REQUEST

Current Zoning: B-1SCD (shopping center district, conditional).
Proposed Zoning: CAC-1(CD) (community activity center-1, conditional)

The petition proposes the development of up to 38 multi-family attached dwelling units. The site is currently developed with a surface parking lot.

**OVERALL
SITE PLAN**

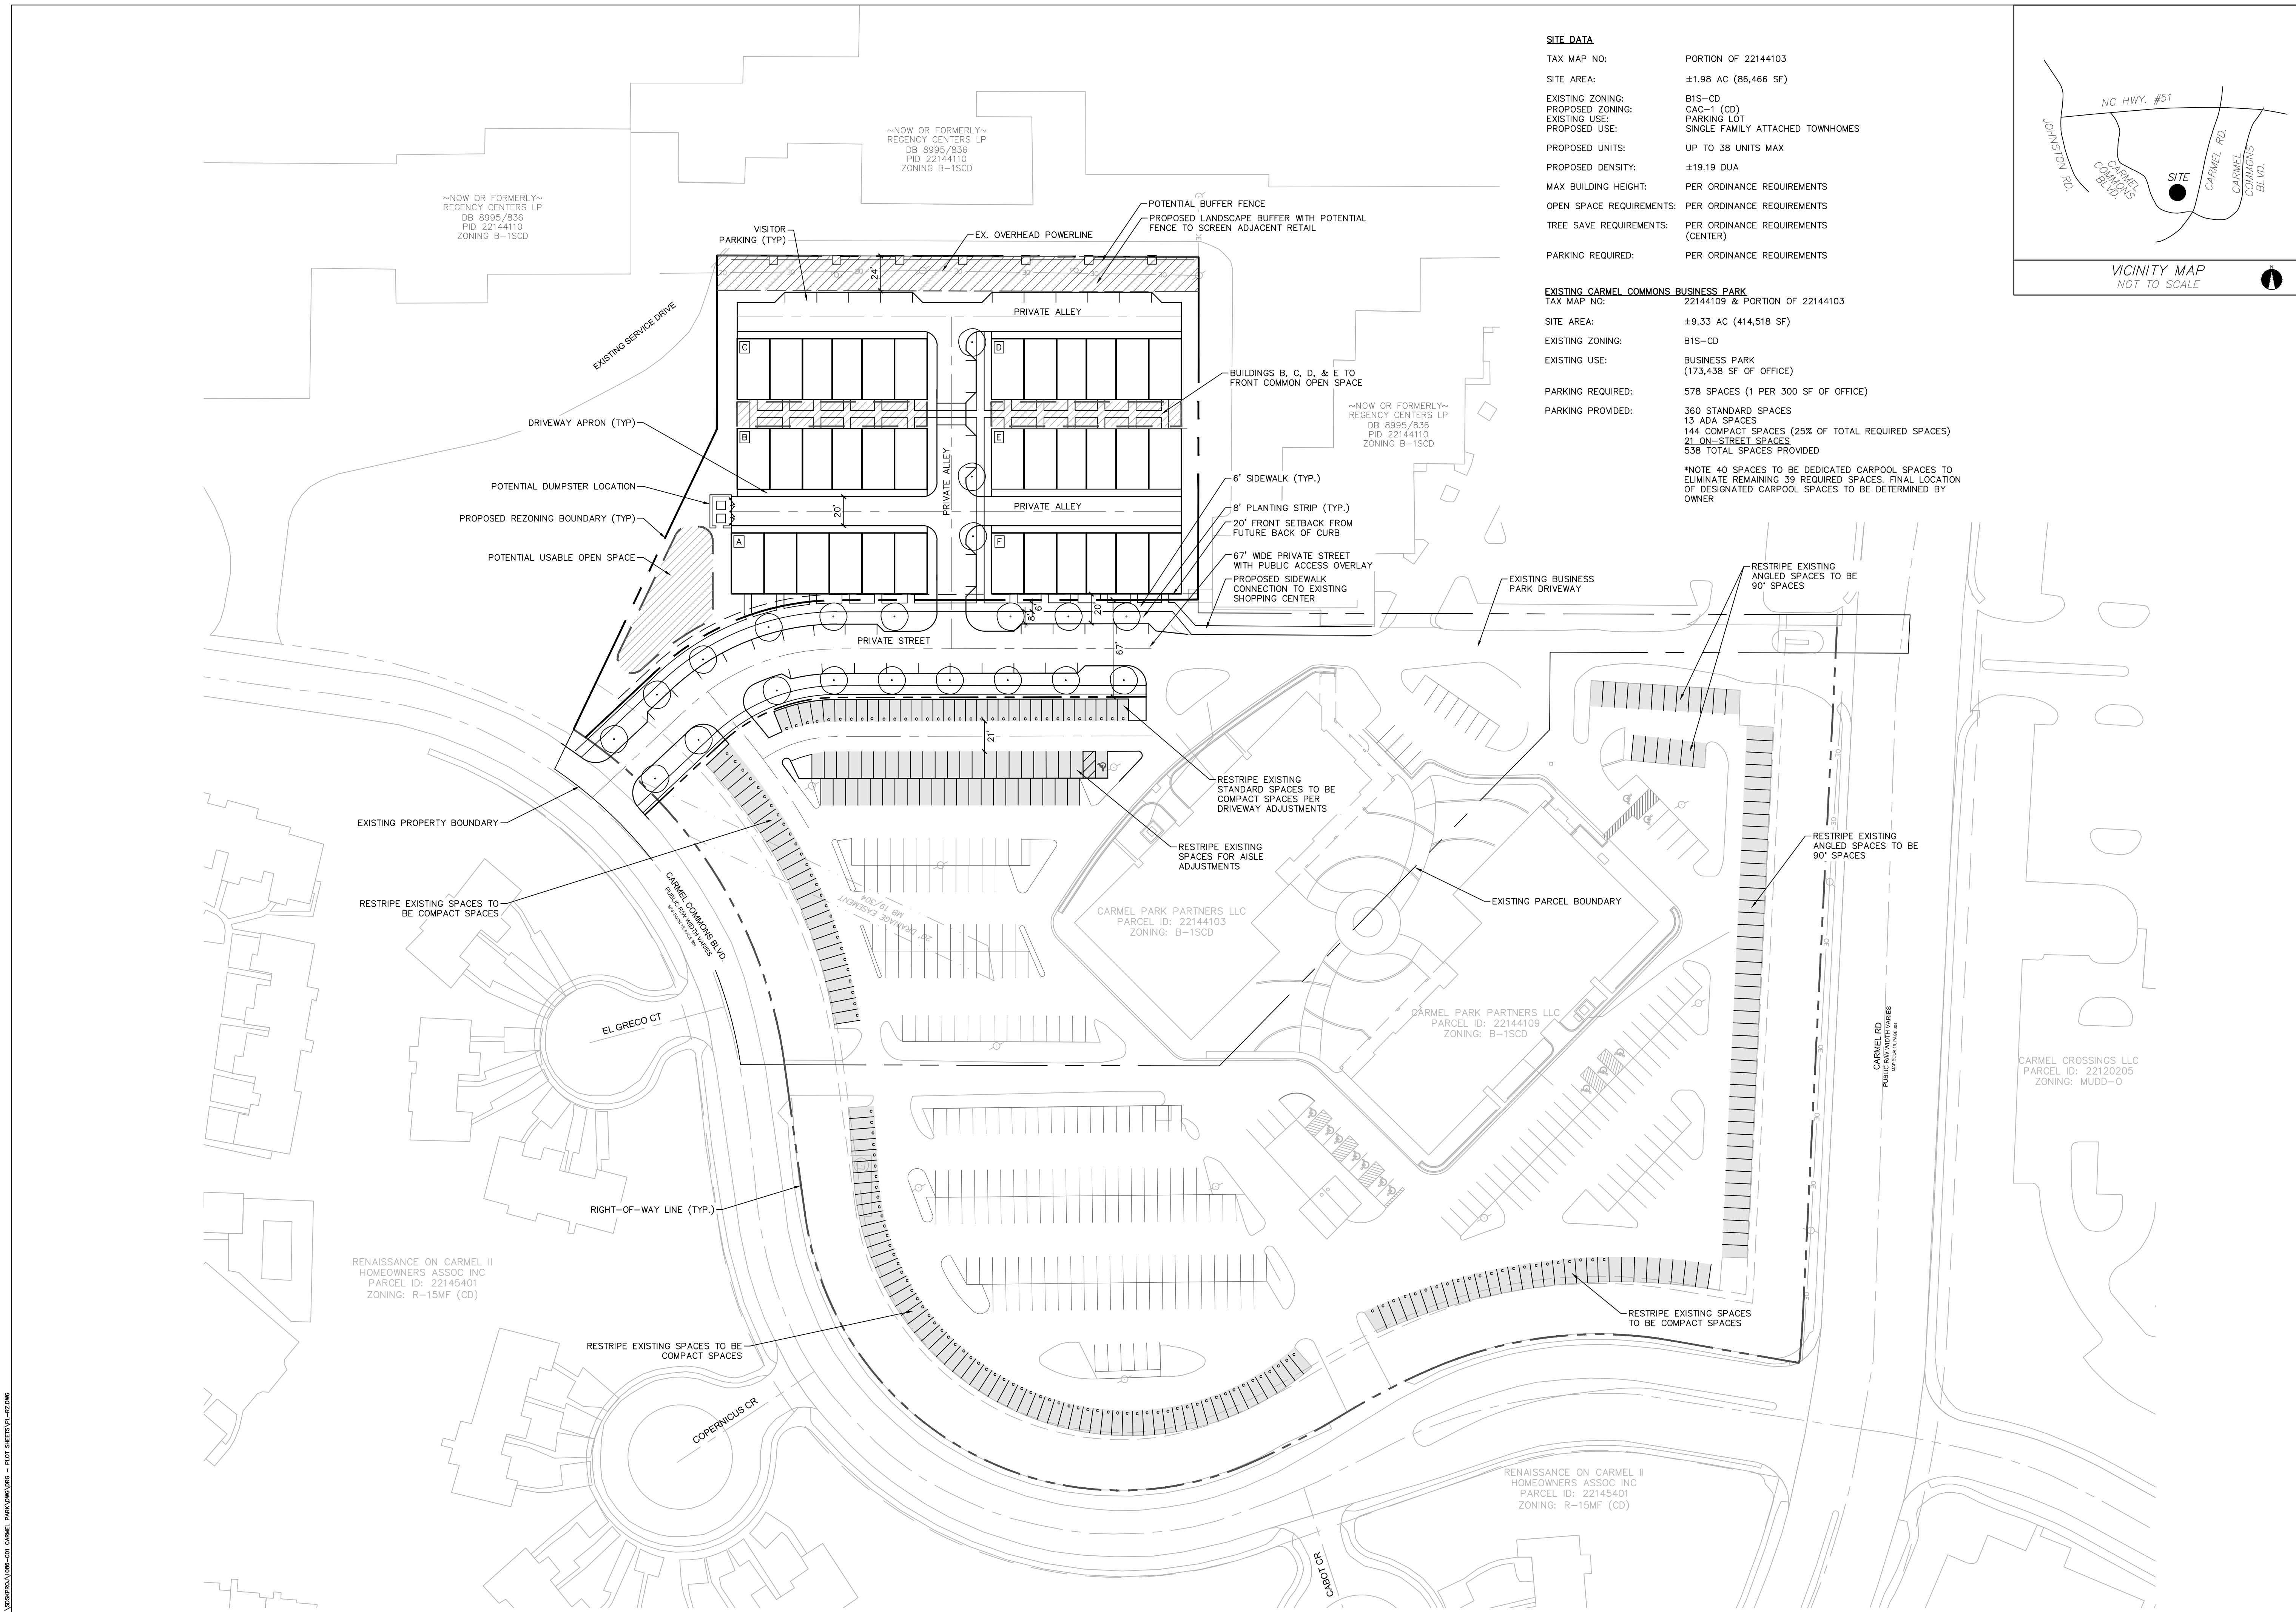
1. ~~Entitlement Services: a berm along the rear (north) property line should be included to replace the existing berm and better screen the development from the shopping center.~~ **Addressed**
2. ~~Entitlement Services: a minimum number and maximum spacing trees to be planted along internal alleys should be include.~~ **Addressed**
3. ~~Entitlement Services: Note regarding existing parking count, and how this development will impact the prior B-1SCD rezoning plan's parking requirements, should be clarified.~~ **Addressed**

SITE PLAN

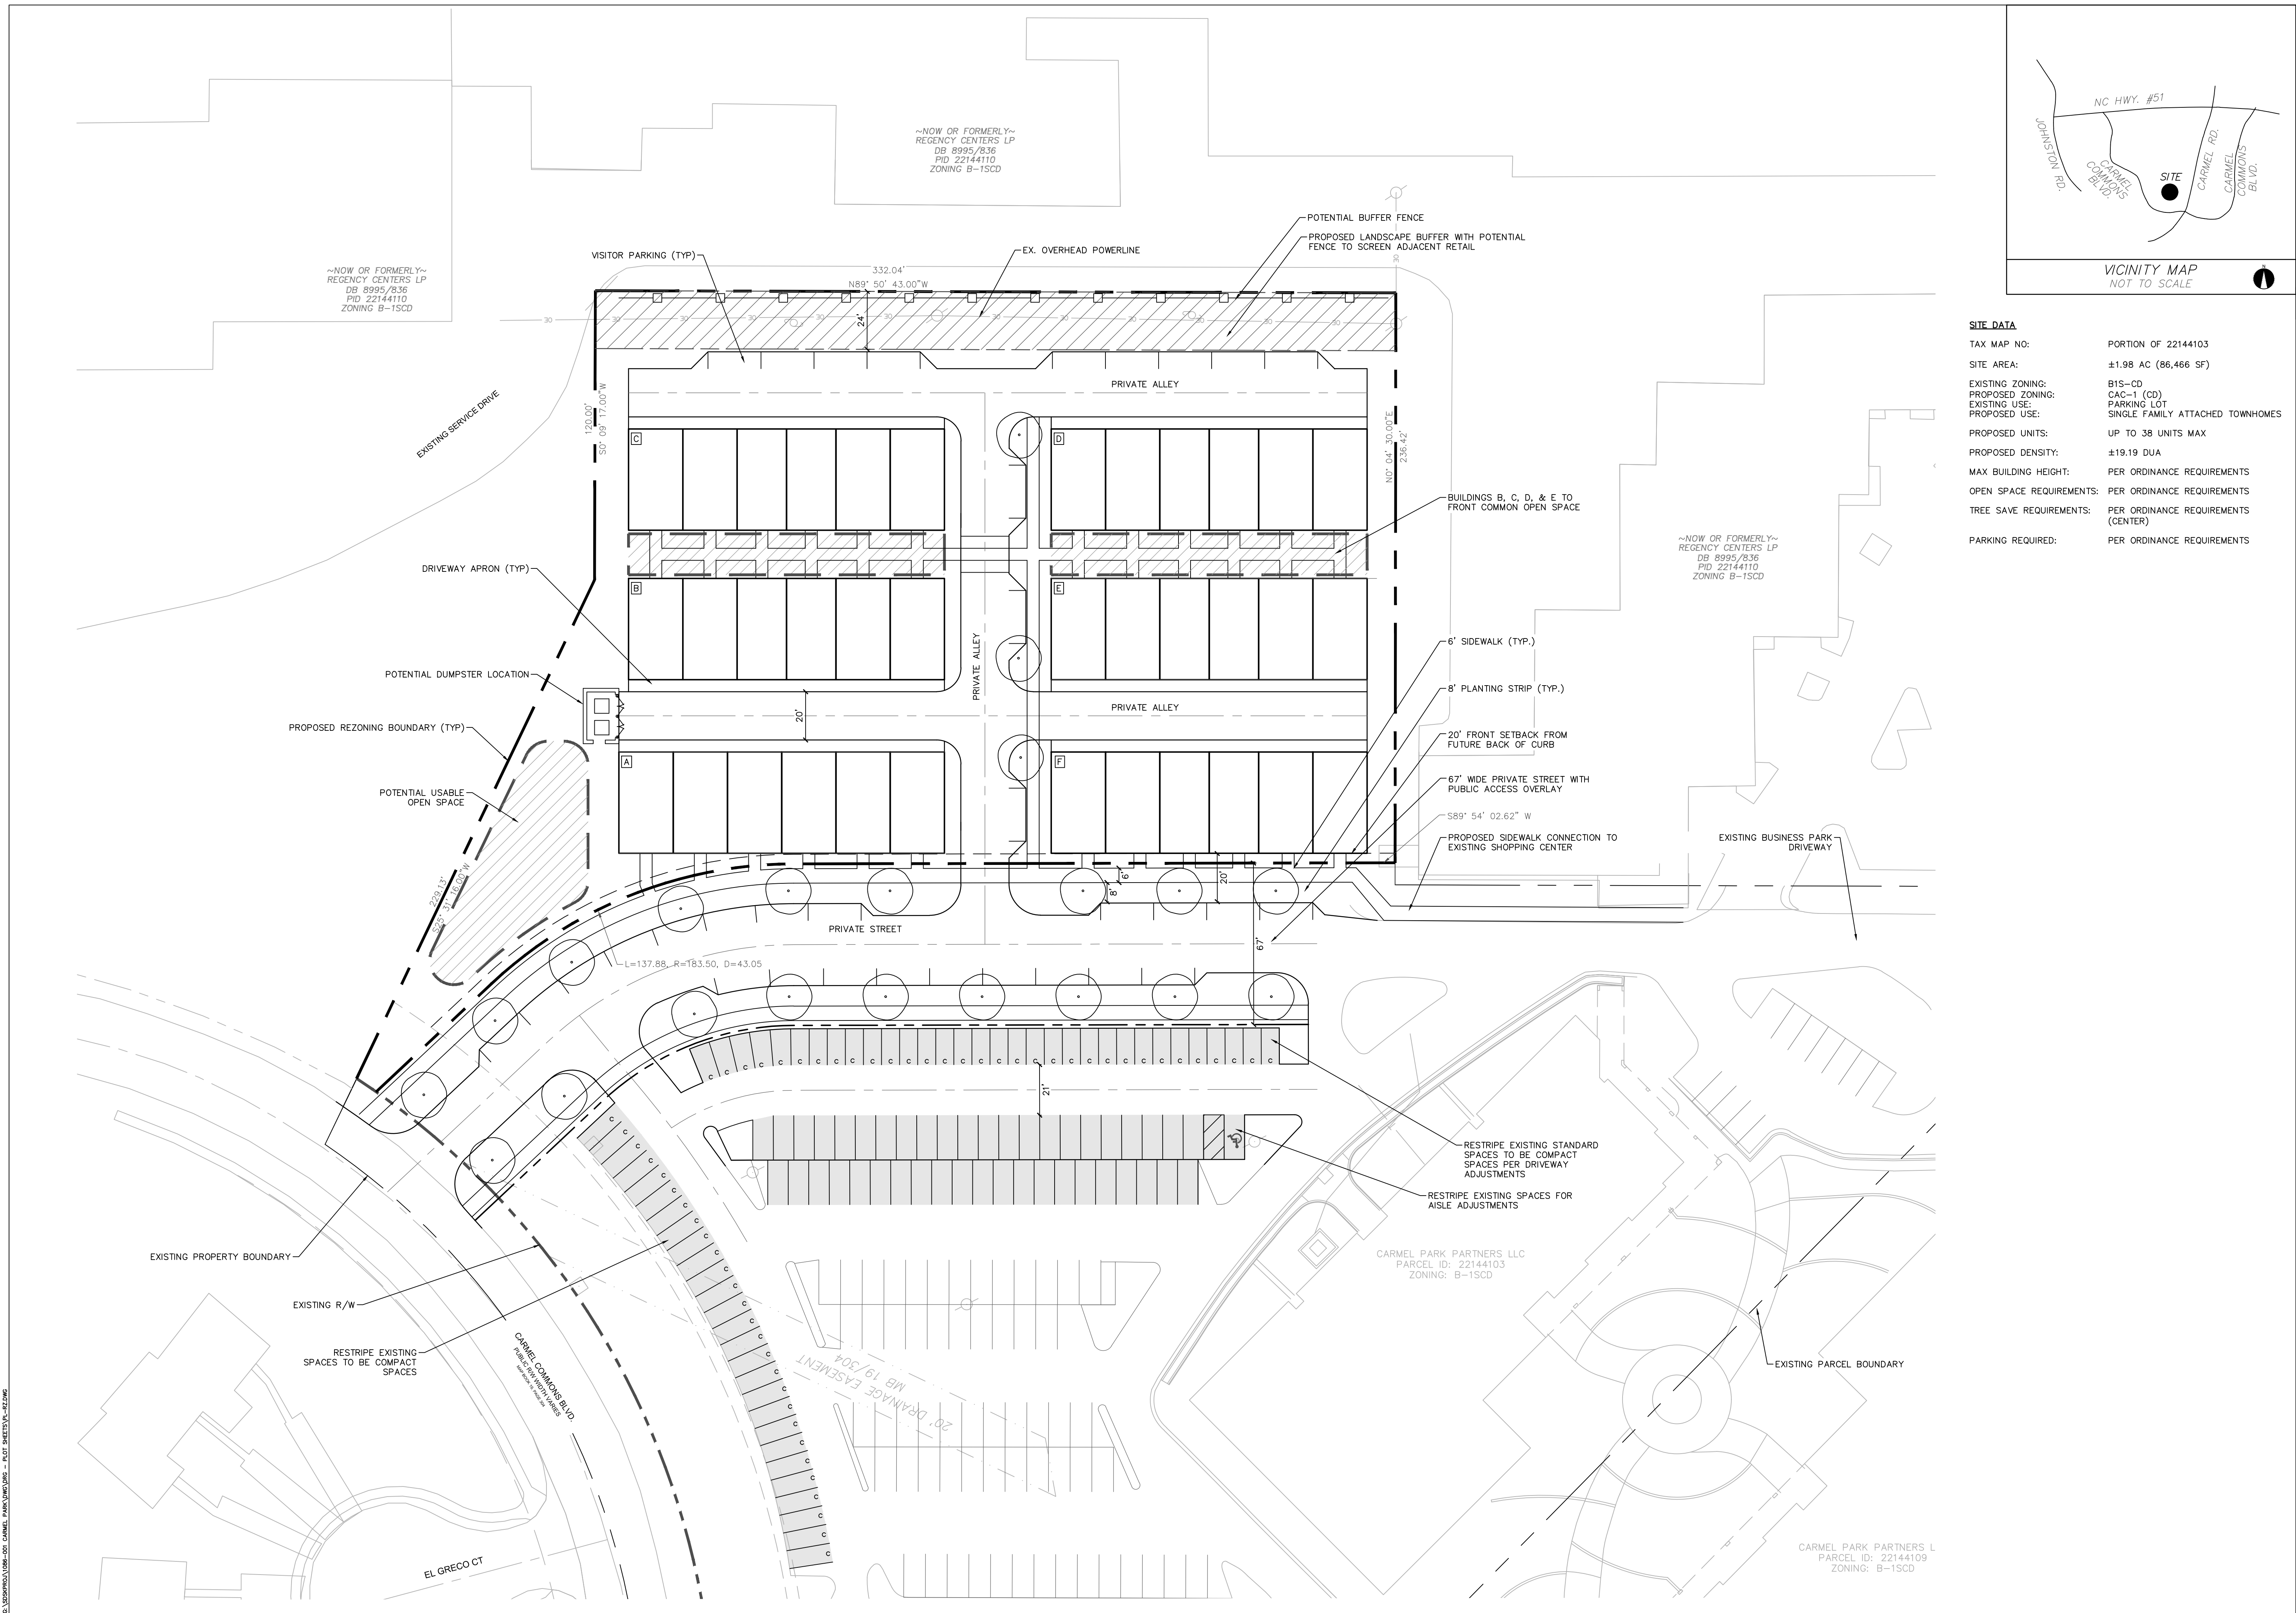
4. ~~Entitlement Services: Maximum building height is stated as 50 feet site data table and 52 feet in conditional notes. Please rectify.~~ **Addressed**
 5. ~~Entitlement Services: Revise boundaries of rezoning to include proposed improvement to private street.~~ **Addressed**
-
